# **A12 Chelmsford to A120 widening scheme**

**TR010060**

## **DEVELOPMENT CONSENT ORDER CHANGE APPLICATION**

### **Change Application Summary Report**

N:\CAD Team\A12 Land Plans\A12_Land_Plans\F13-Change_Consultation_31032023.dwg - 31/03/2023 16:00:18 - SS - glones

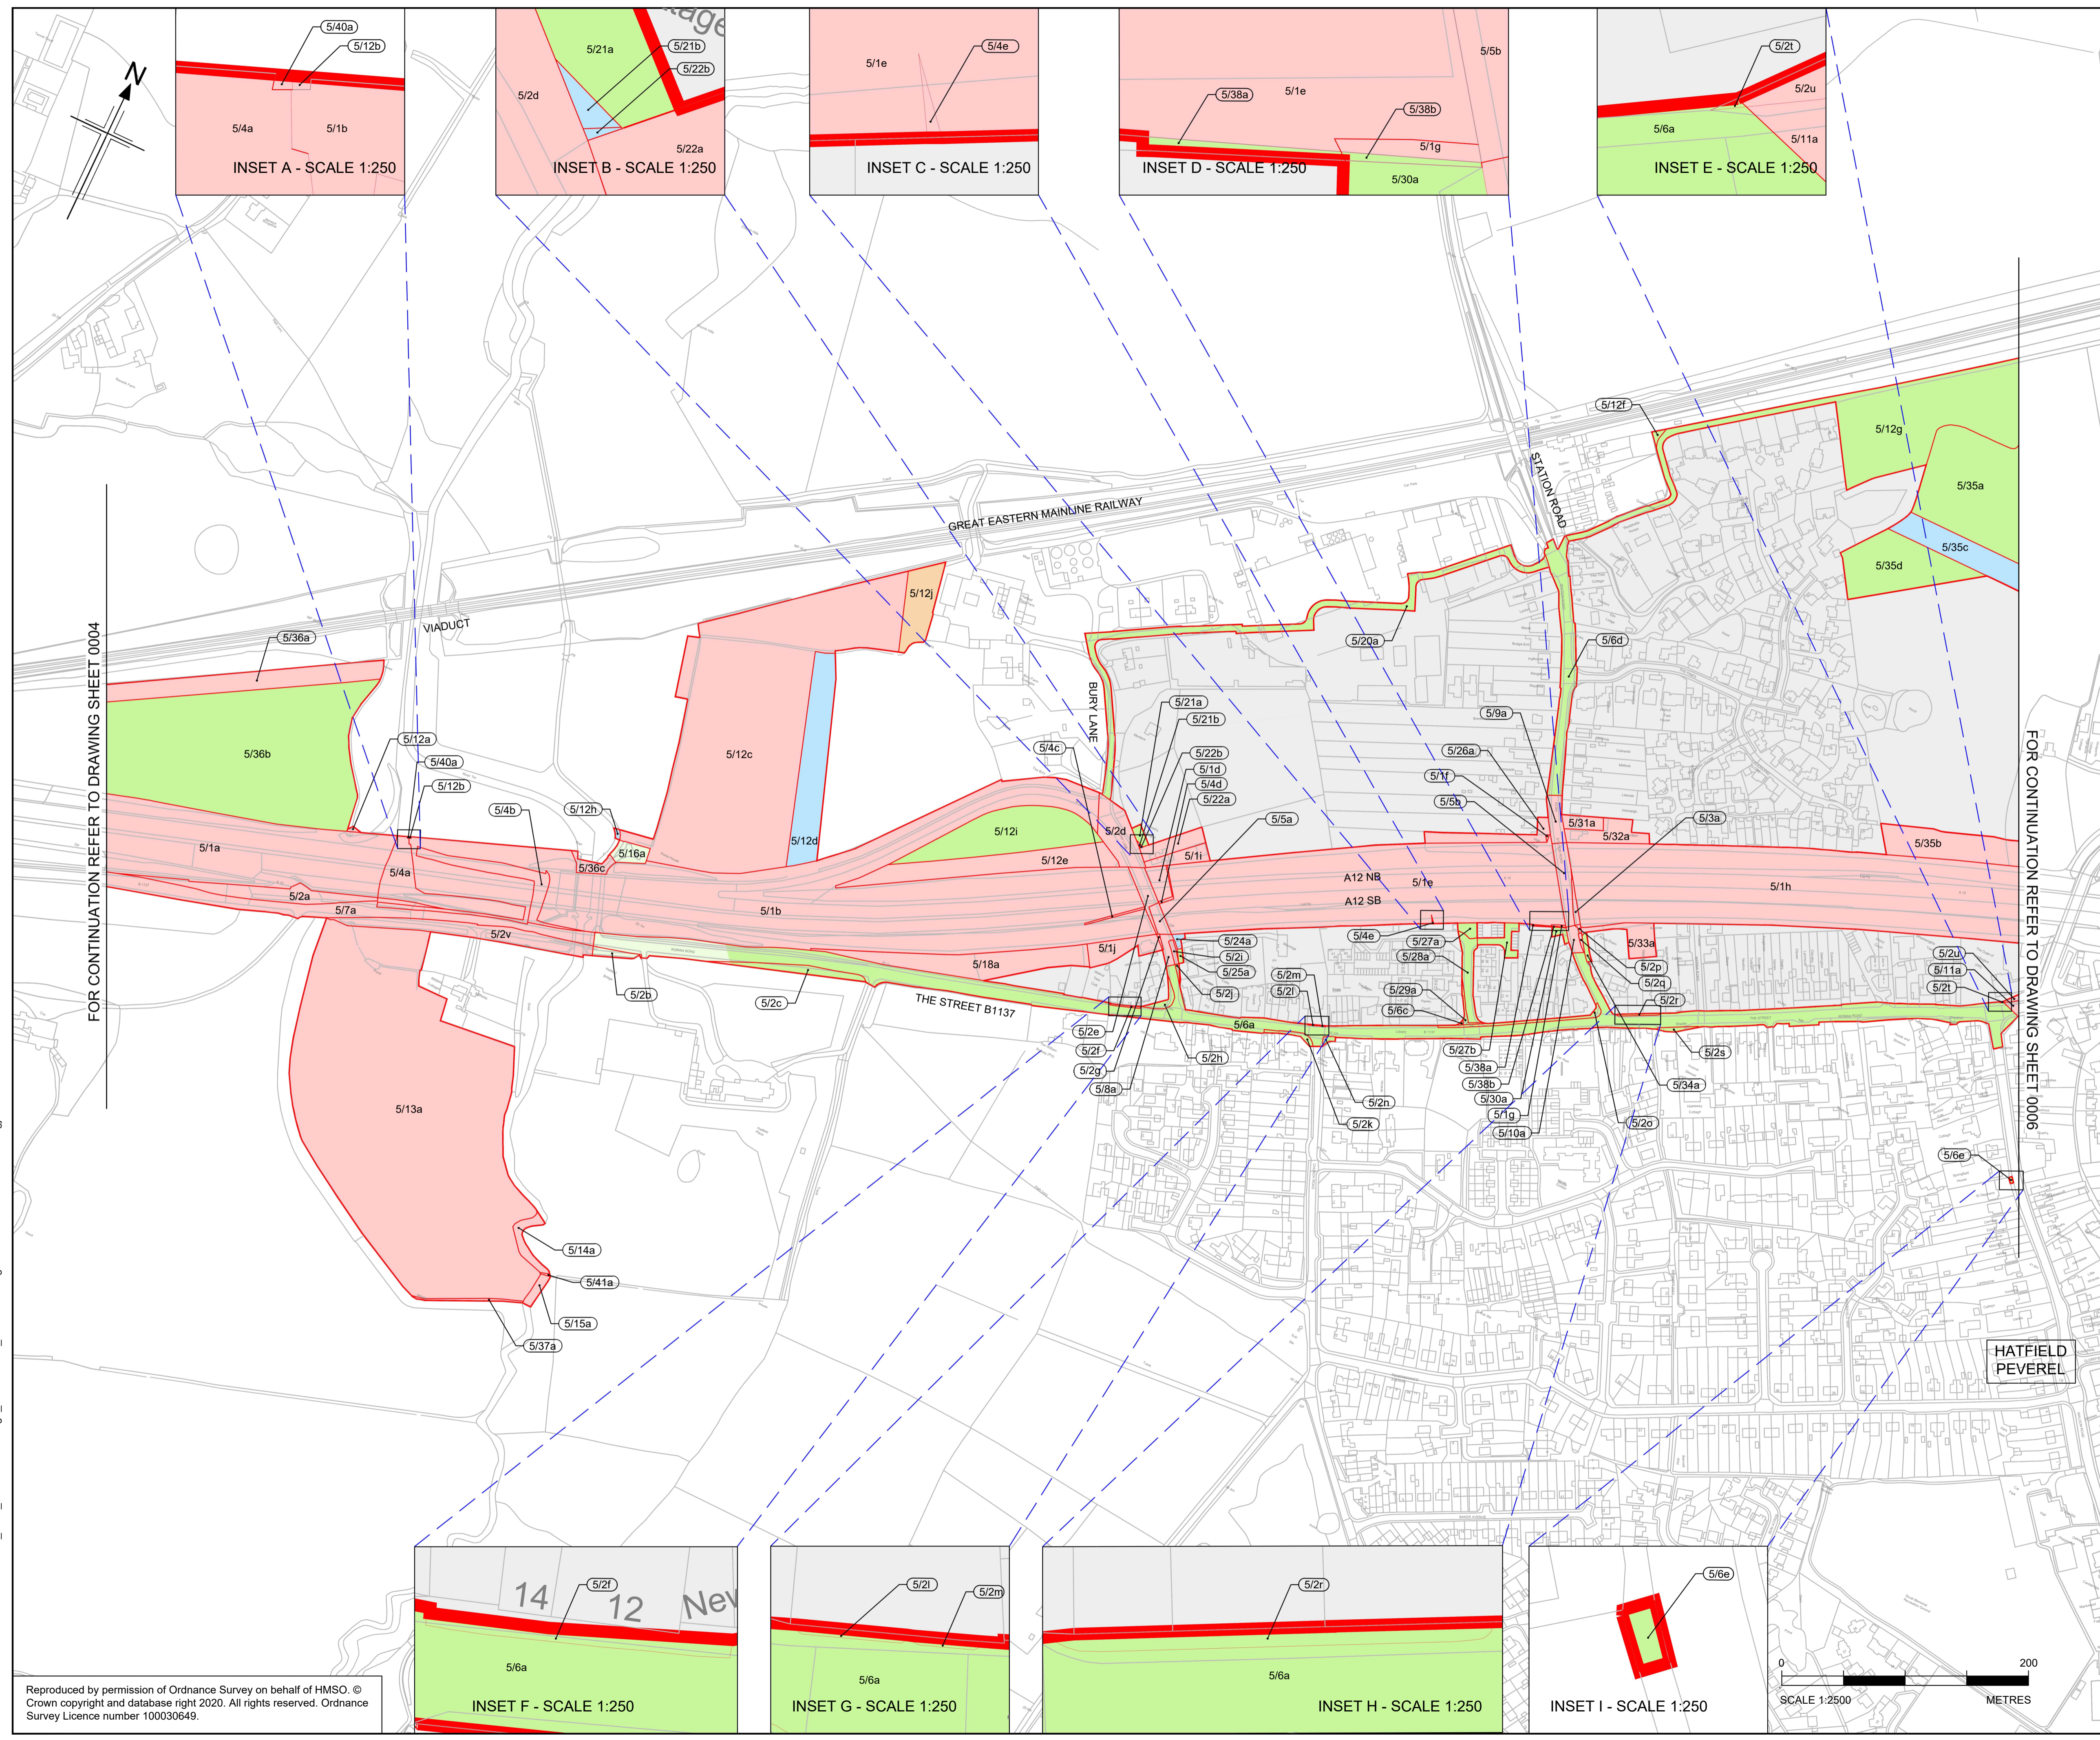
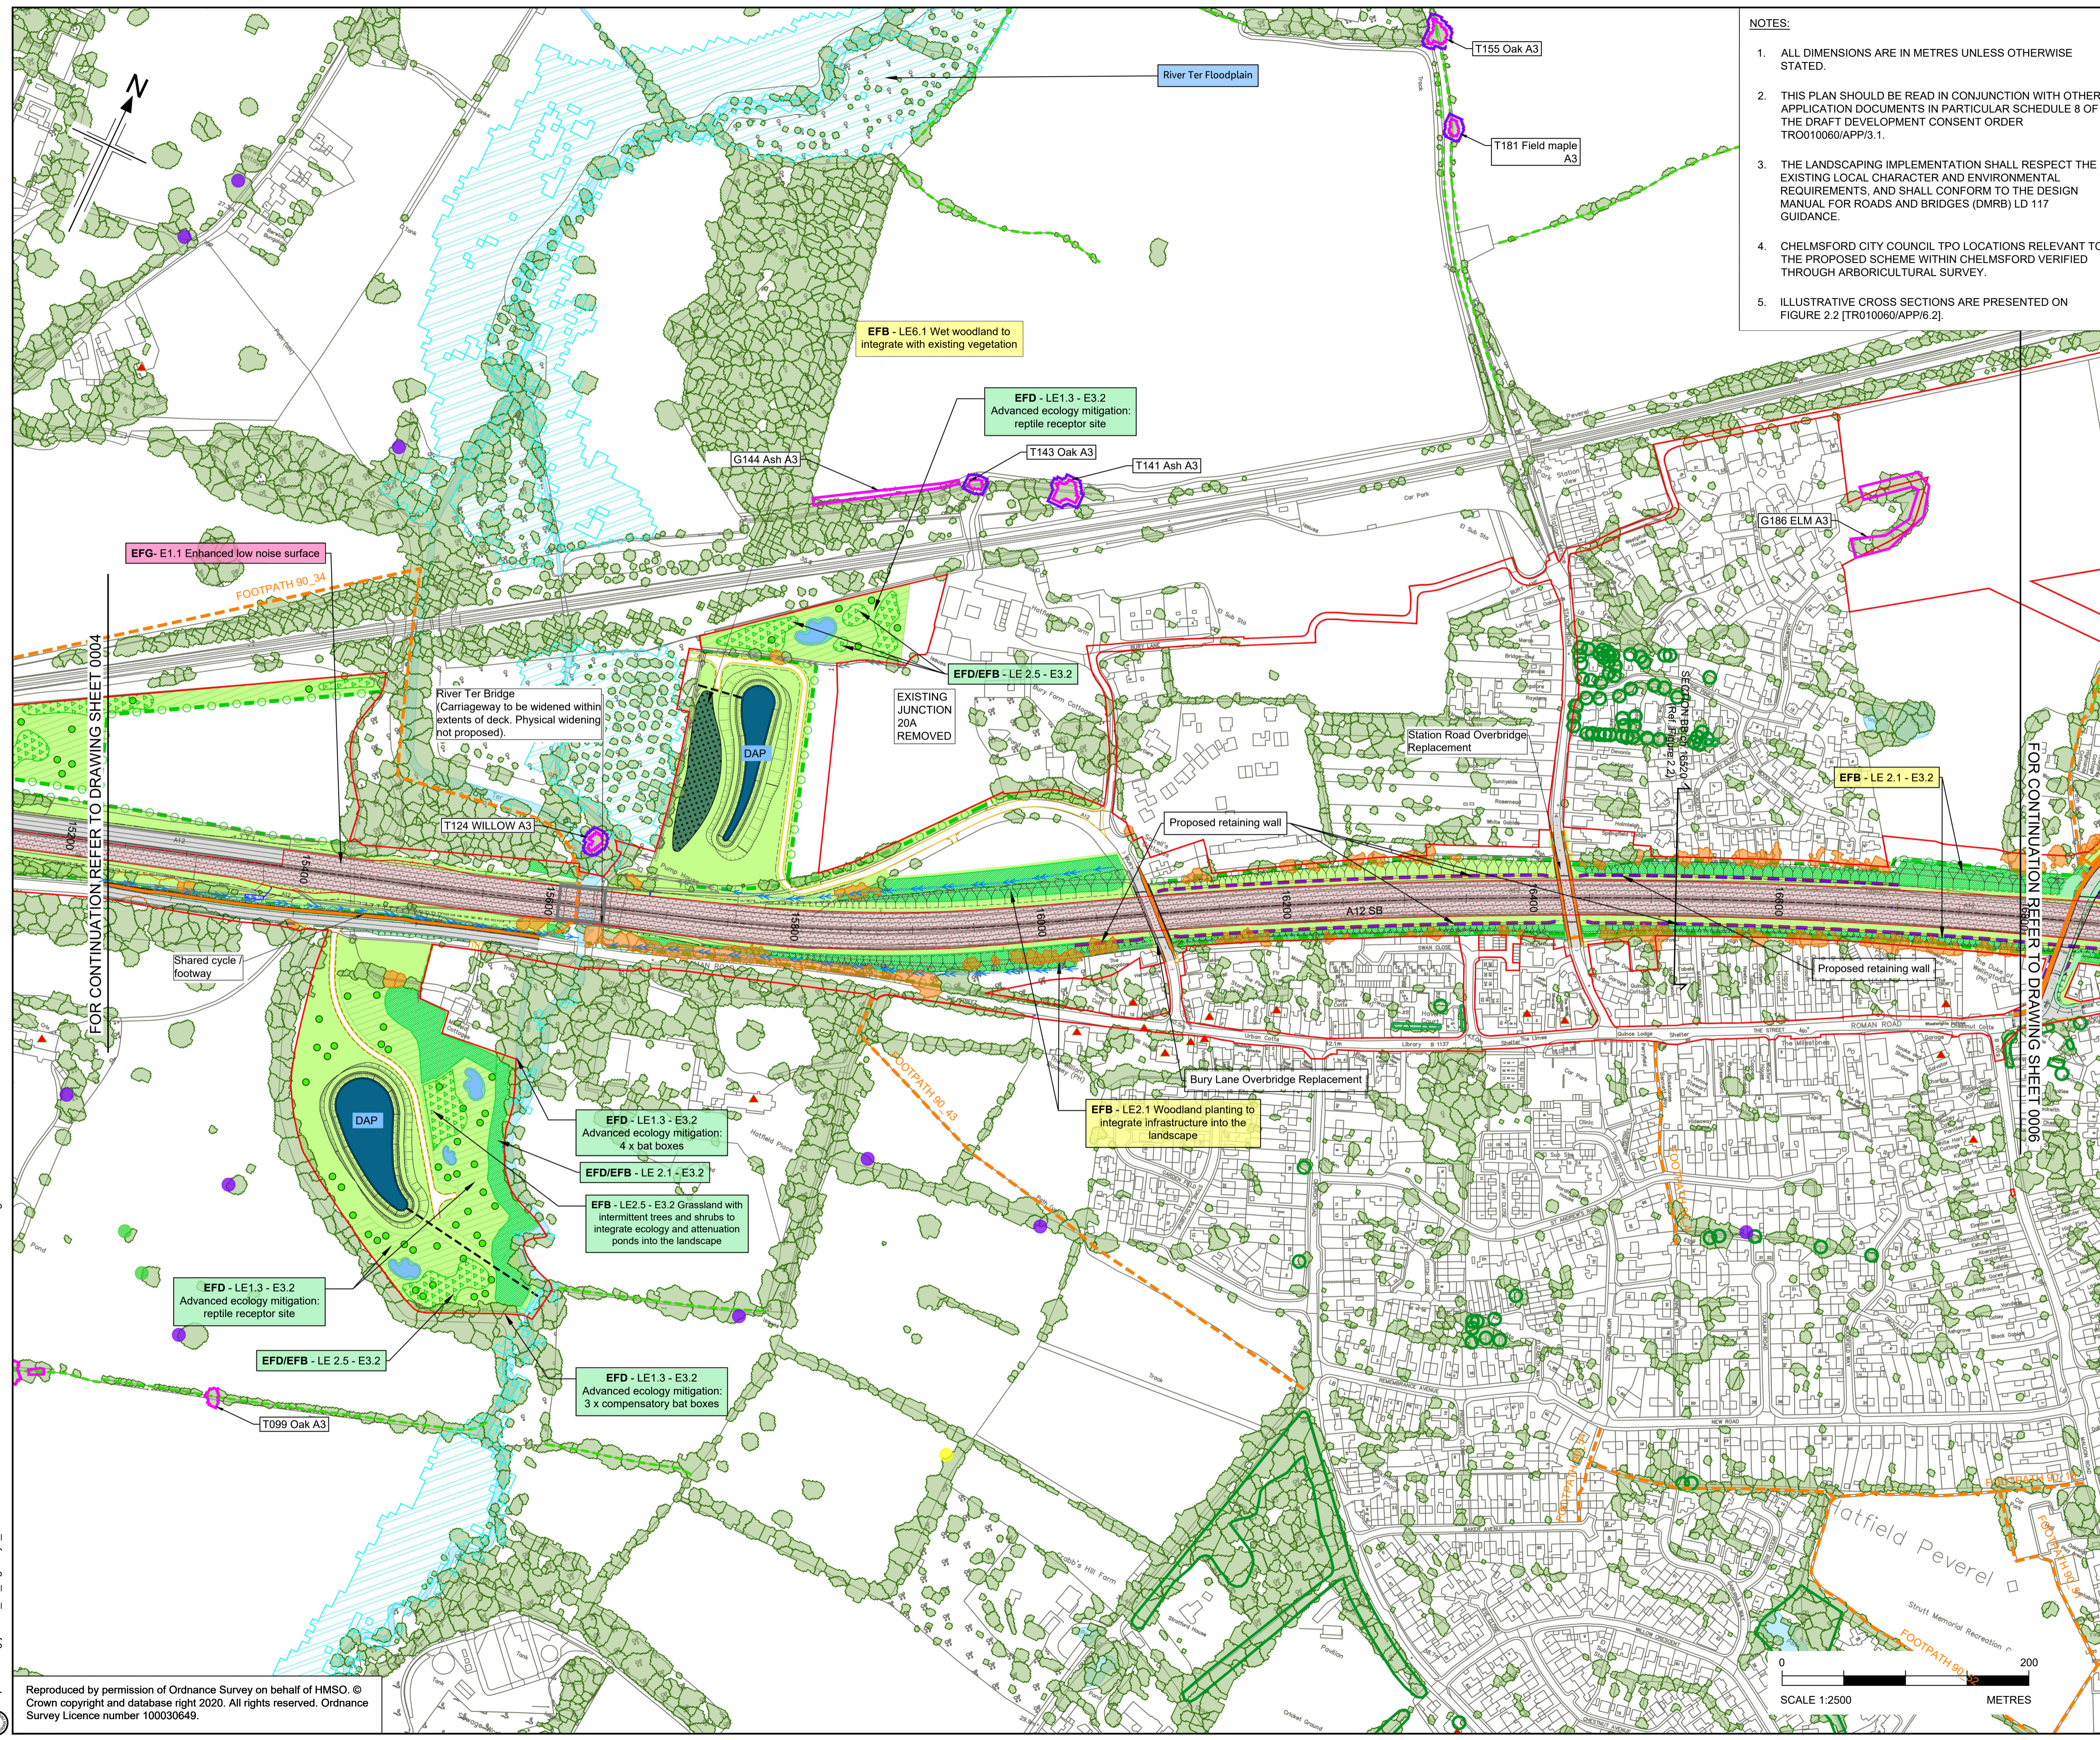
- 2.3.1 The proposed change is to the extent of an Environmental Mitigation Area as shown on the General Arrangement Drawings (Map Book 2) [TR010060/EXAM/10.6] to accommodate a pumping station at the Bellway Homes Site, Hatfield Bury Farm, Bury Lane, Hatfield Peverel (planning permission 19/01803/FUL). This falls within the Order Limits of the proposed scheme and specifically land plot 5/12c as shown on Sheet 5 of the Land Plans [APP-018].
- 2.3.2 The Applicant proposes to change the land use at this location from compulsory acquisition for ecological mitigation, to, land not subject to powers of compulsory acquisition or temporary possession. The small area of ecological

mitigation that will be lost is a negligible decrease in the overall land being provided for ecological mitigation across the whole proposed scheme.

2.3.3 This design change is illustrated in Figure 2.2 and shown on Map Book 2 – Anglian Water Pumping Station (Bury Lane, Hatfield Peverel) - Part 1 of 1 [TR010060/EXAM/10.6].
